**WARWICKSHIRE COUNTY COUNCIL  
(20040686)**

**Hinckley National Rail Freight Interchange**

**Summary Written Representations  
October 2023**

Figure 4.6: Railway Stations

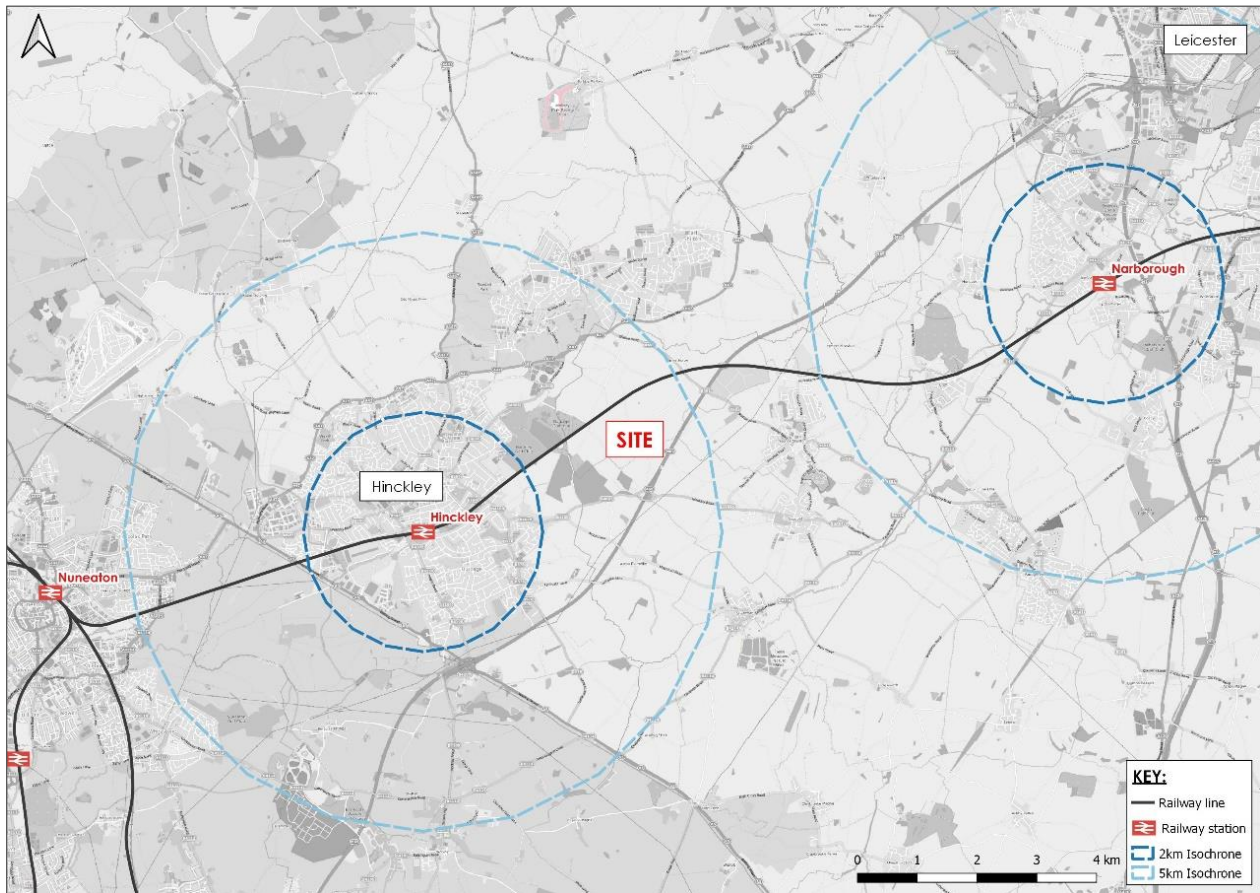
- 2.7. Warwickshire County Council has raised concerns over the proposals for

sustainable transport proposed as part of the development, particularly around the ability to ensure that employees living in the settlements to the north of the county can access bus based public transport to reach the site.
